## Appeal Decision

**Appeal Ref: APP/R5510/D/25/3361541**

**364 Victoria Road, Ruislip HA4 0ET**

- The appeal is made under section 78 of the Town and Country Planning Act 1990 (as amended) against a refusal to grant planning permission.
- The appeal is made by Mrs Rajal Shah against the decision of the Council of the London Borough of Hillingdon.
- The application ref. is 3415/APP/2024/3176.
- The development proposed is the construction of a single storey rear extension and the installation of a dropped kerb.

2 Proposed Block Plan

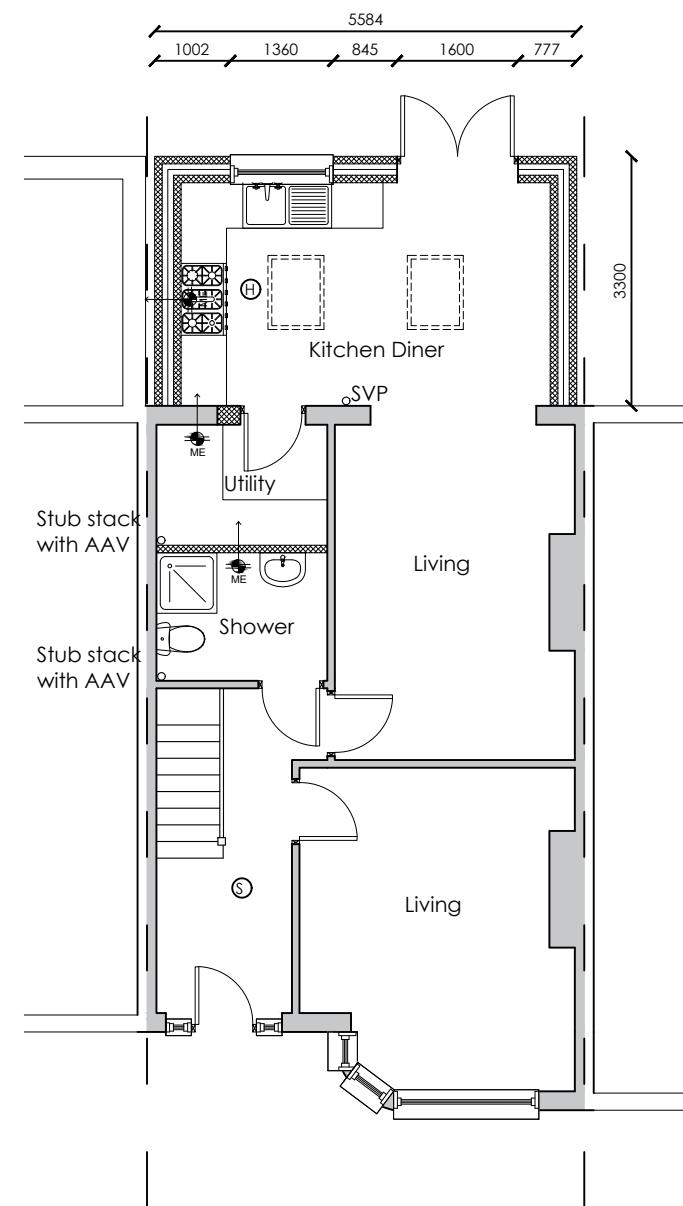
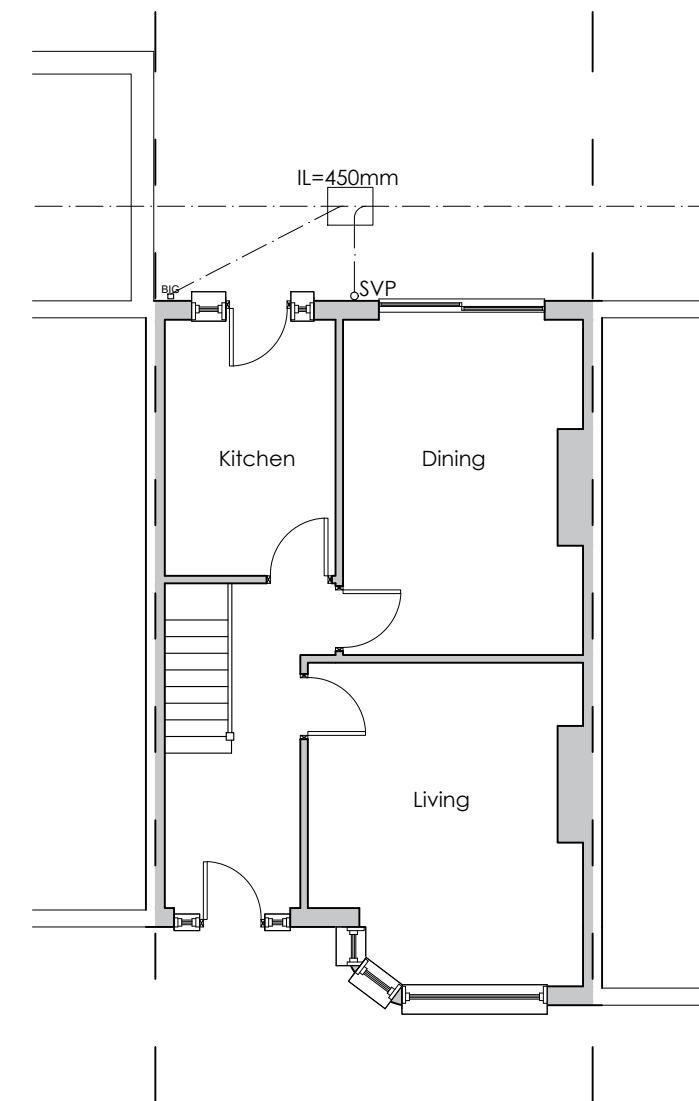
7. The property is situated on a straight, busy section of Victoria Road, which is a classified road. On-street parking is available. The footpath in front of the site is well-used by pedestrians. The use of the front area of the appeal site for vehicle parking would be likely to involve vehicles accessing the crossover and hardstanding/parking area which would involve either reversing in or out of the site directly into or out of the flow of traffic. This manoeuvre would be likely to lead to increased risk of collisions with vehicles or with pedestrians on the footpath. It would also be likely to require traffic on Victoria Road to slow down or stop which would be detrimental to highway safety and to the convenient and free flow of traffic. I note these are also the conclusions of the Highway Authority.

8. On this issue I find that the proposed crossover would result in unacceptable risks to highway and pedestrian safety and be contrary to policies T4 of the London Plan (2021) and policies DMT 1 and DMT 2 of the Hillingdon Local Plan Part 2: Development Management Policies (2020).

9. Turning to the issue of visual amenity, the creation of the on-site parking area would involve the loss of the boundary treatment to the site frontage and also the majority of the soft landscaped front area, and the grass verge. These features contribute to a pleasant and vegetated streetscape which in turn brings visual amenity and character to the area. I have considered if any planning conditions might be attached to a permission which might appropriately mitigate the harm to visual amenity, but I do not consider that specifying surfacing materials and/or specifying planting could sufficiently compensate for the loss of amenity.

10. Consequently, on this issue I find that the proposed crossover and hardstanding would unacceptably harm the character and appearance of the streetscene and would be contrary to policy BE1 of the Hillingdon Local Plan: Part One Strategic (2012) and policies DMHB 11 and DMHB 12 of the Hillingdon Local Plan: Part Two - Development Management Policies (2020).
